ENG-SF22023-R2-GEC.pdf Markup Summary

**GRADING & EROSION
CONTROL INTERIM PLAN**

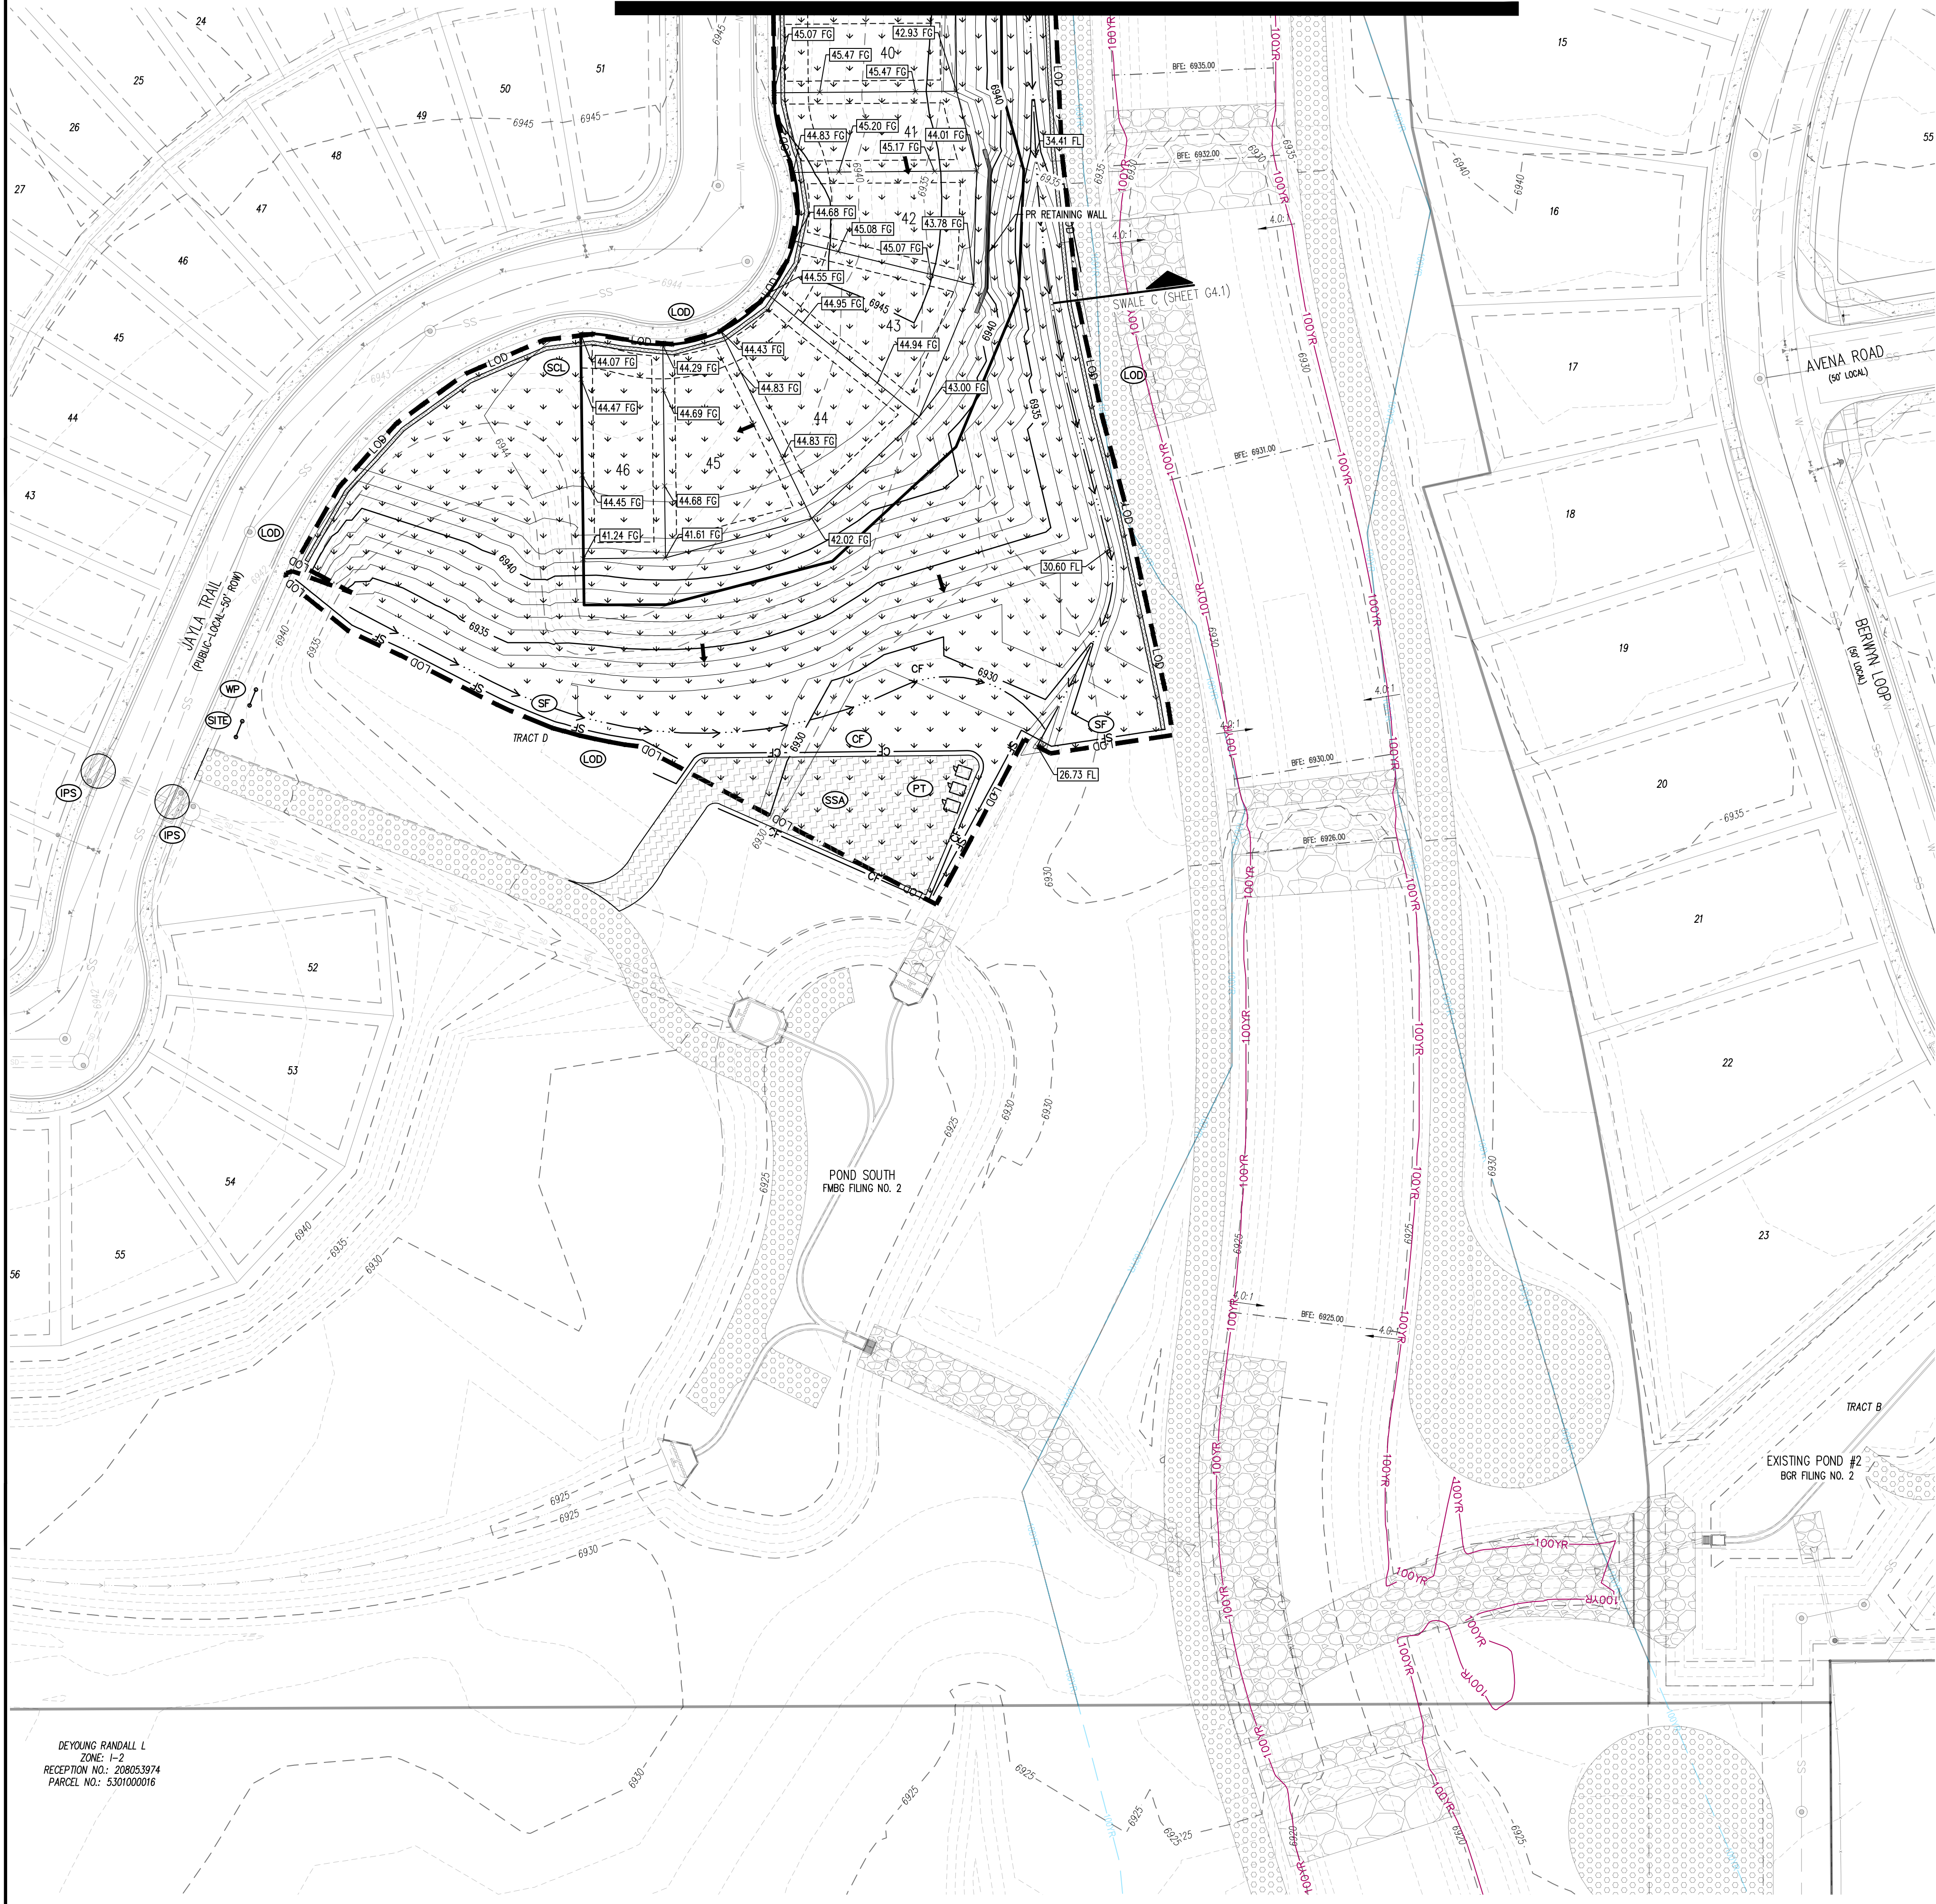
Map DR 2.3 in FDR has this labeled as "Existing Pond #1. Which is it? Revise to remove discrepancies/confusion.

Is a 5-foot wall needed?
